Summary of contribution to CAH1.

APFP Regulation: 5(2)(a)
Application Doc no.: EN010168/APP/6.2
Drawing no.: CW.ES.BR.14

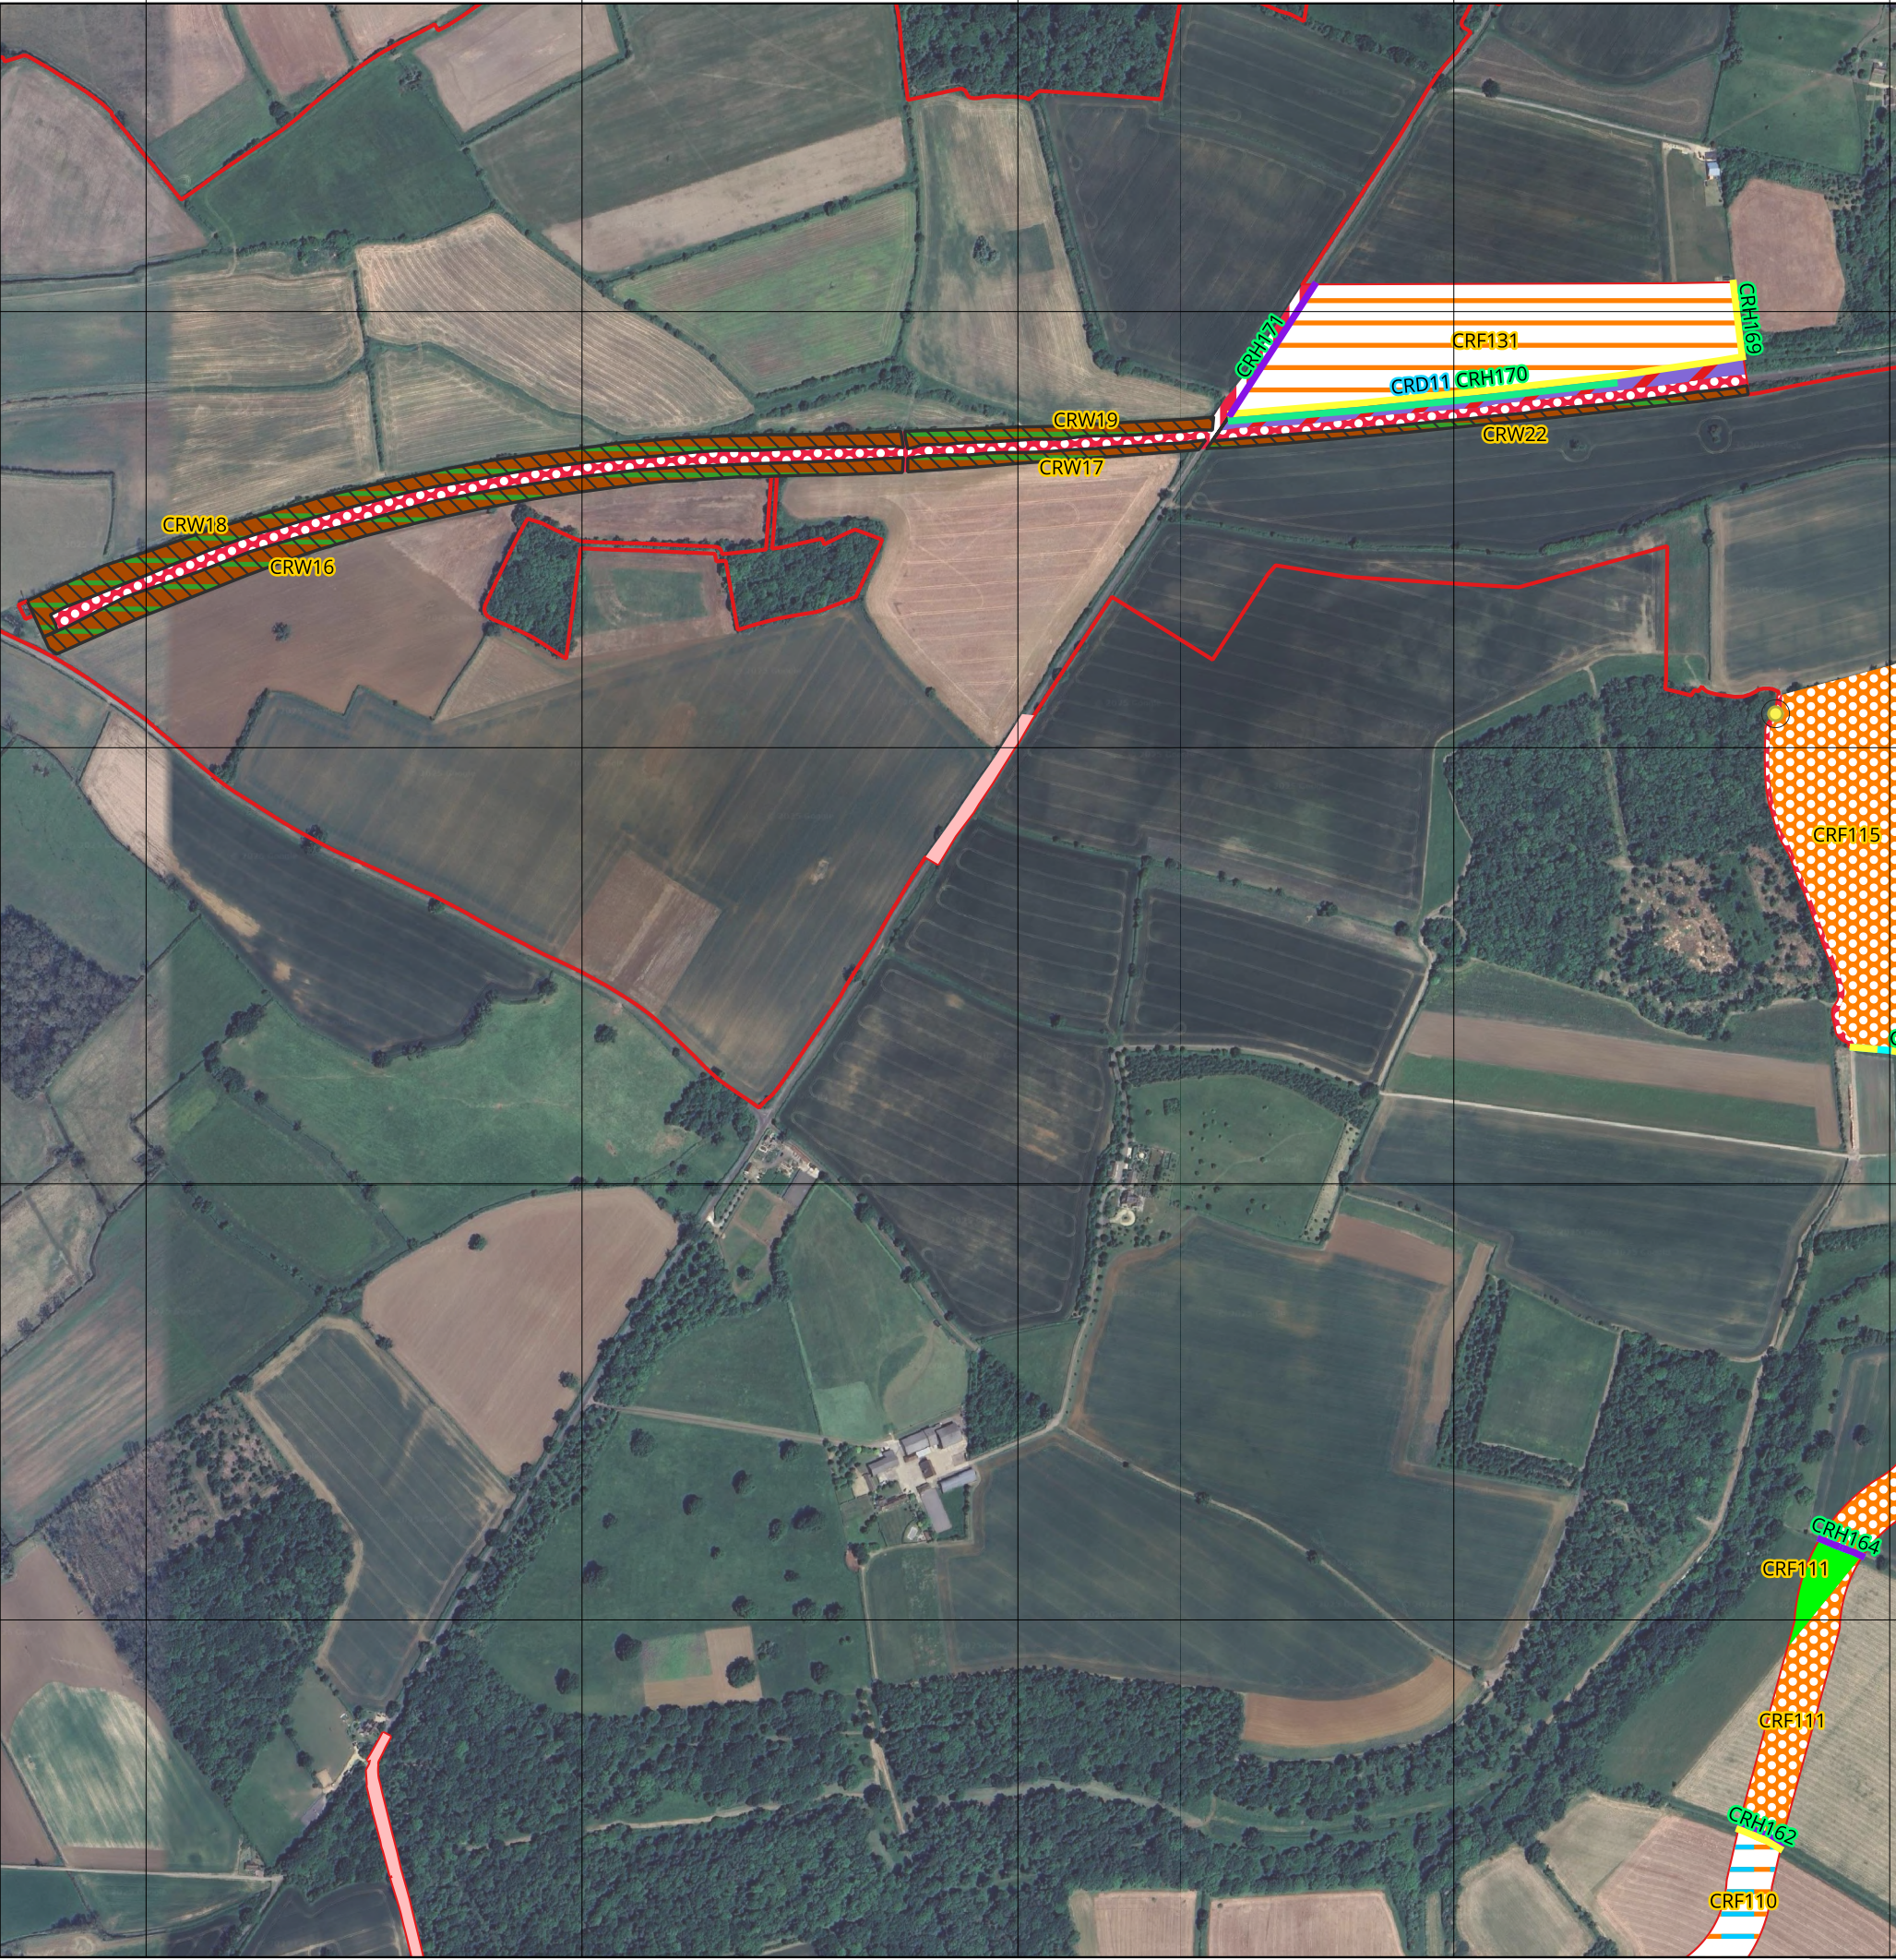
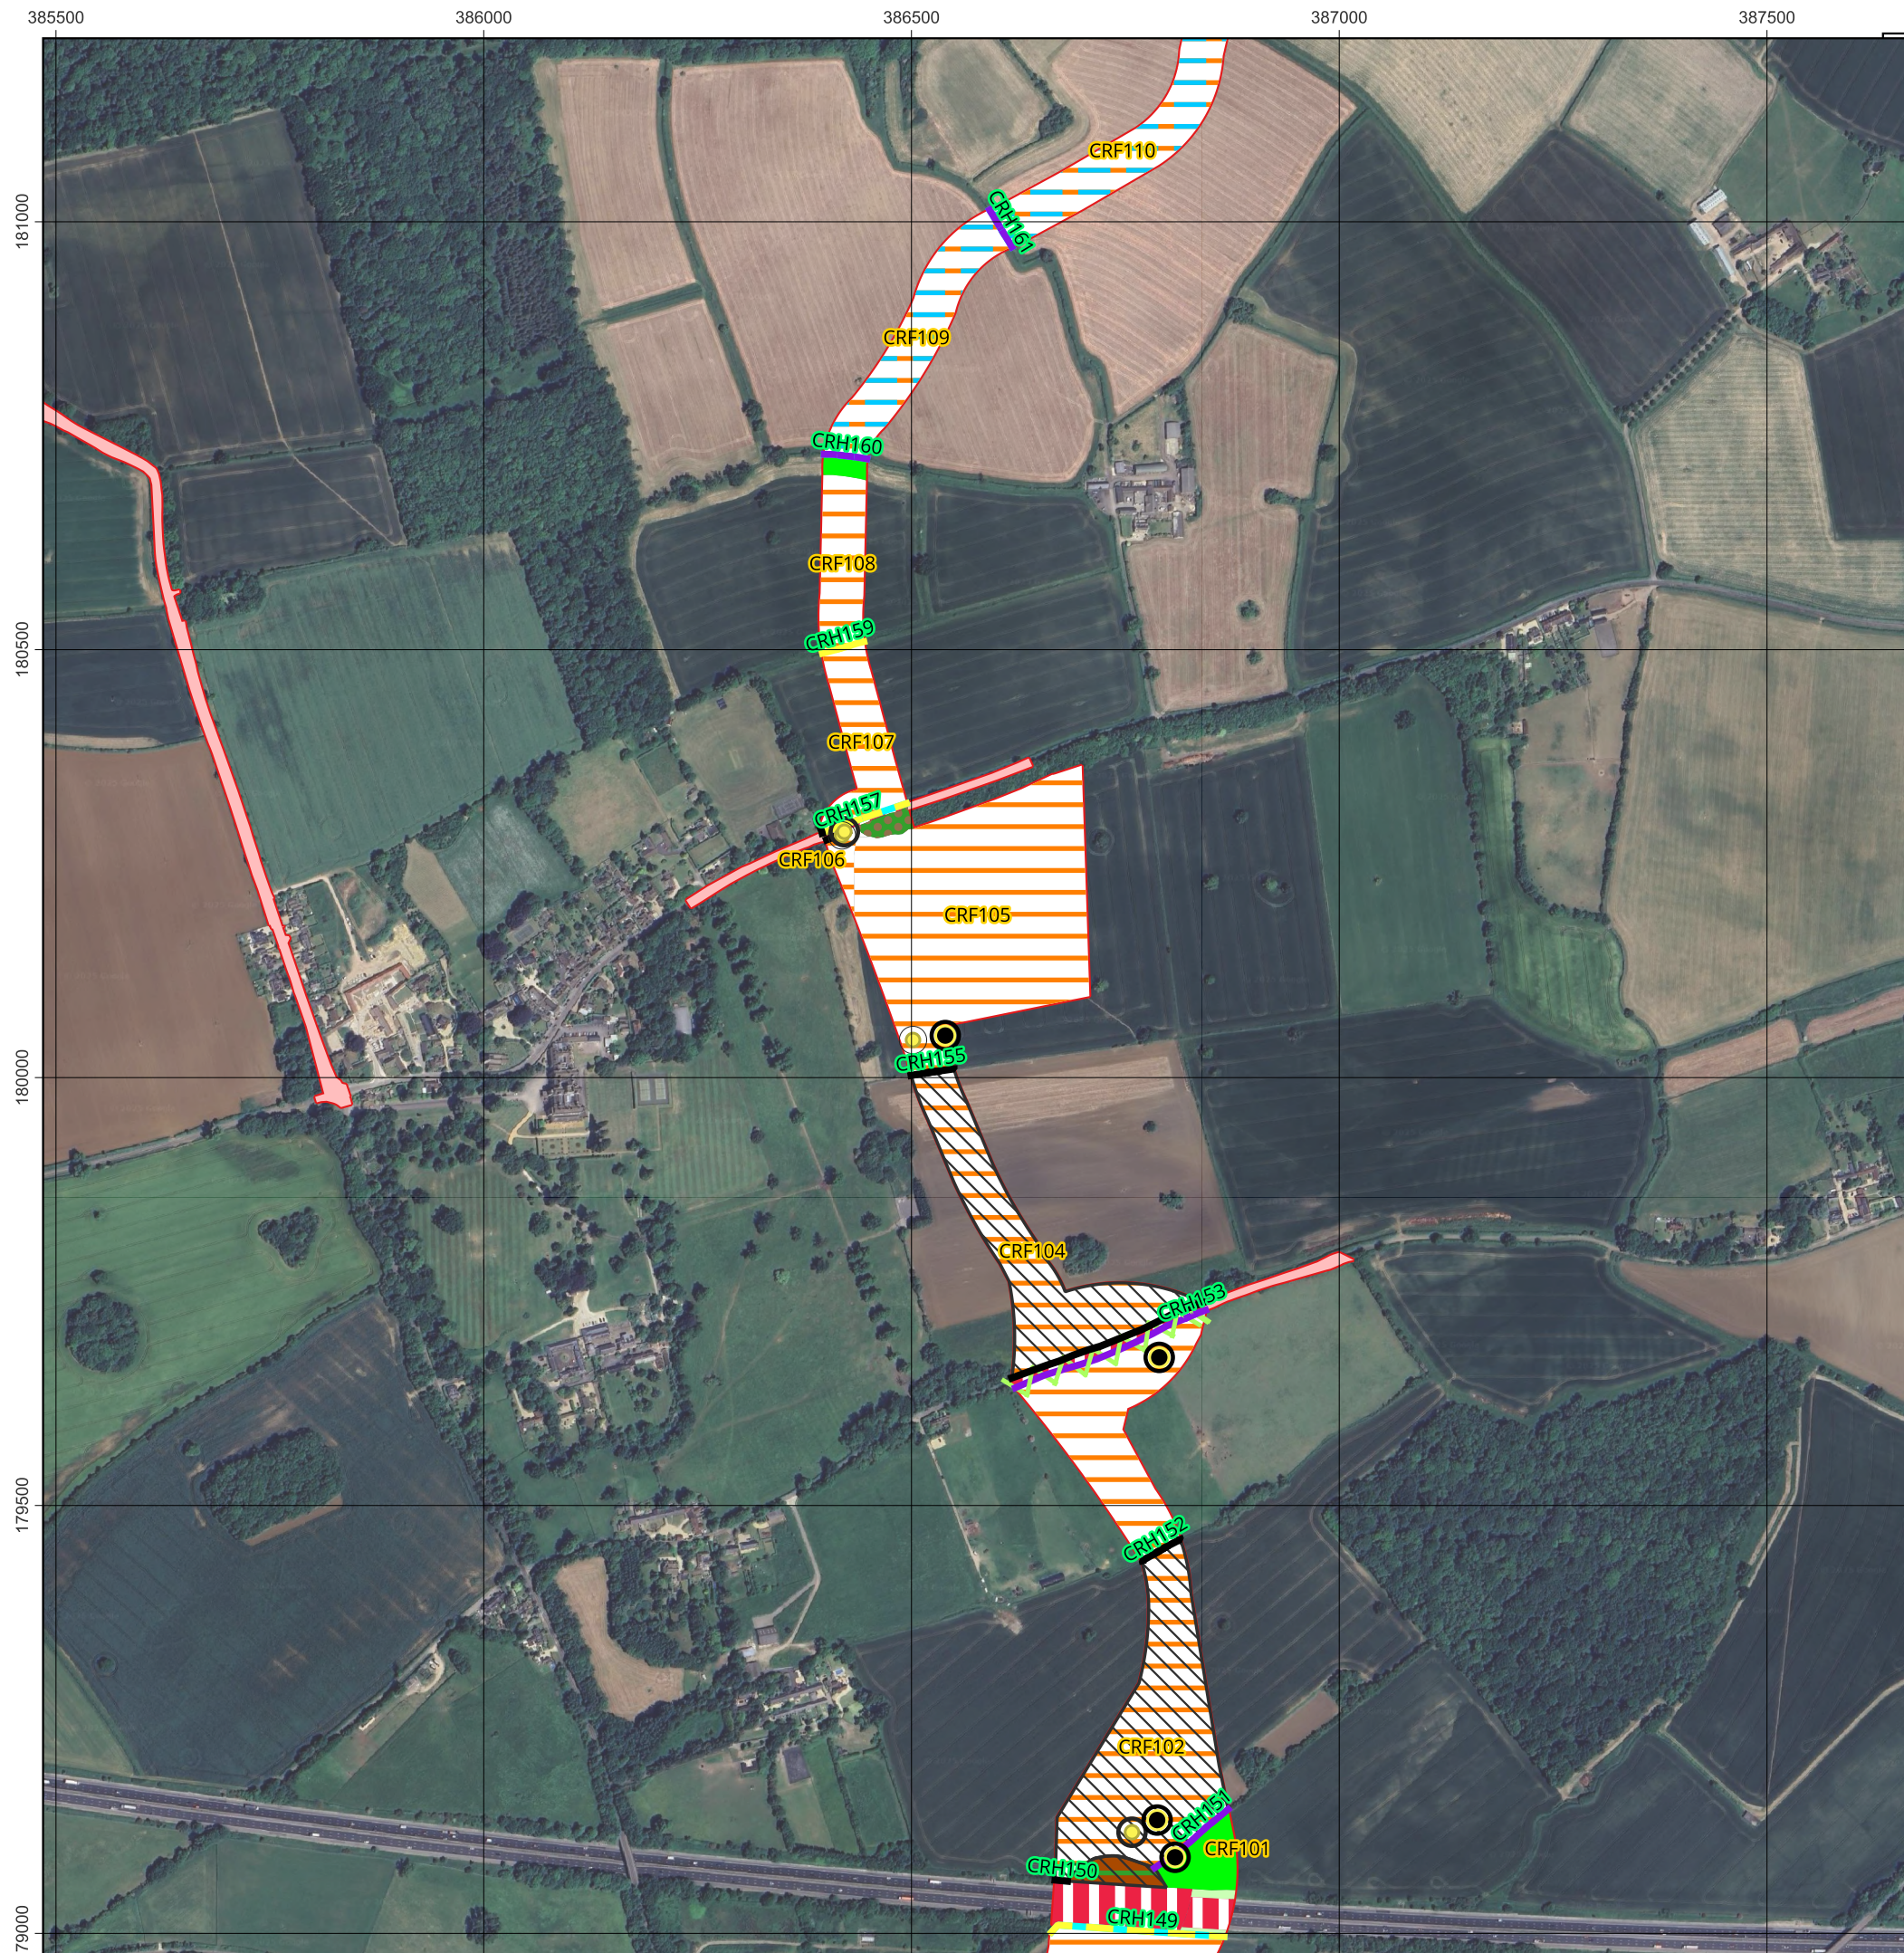
A further observation revolves around the Baseline habitat map and the designation of non-cereal crop and cereal crop. I'm wondering if there is any meaning to these criteria? Clearly the designation was recorded at the time of the survey but it is now incorrect, due to crop rotation. Are there conclusions drawn from this data?
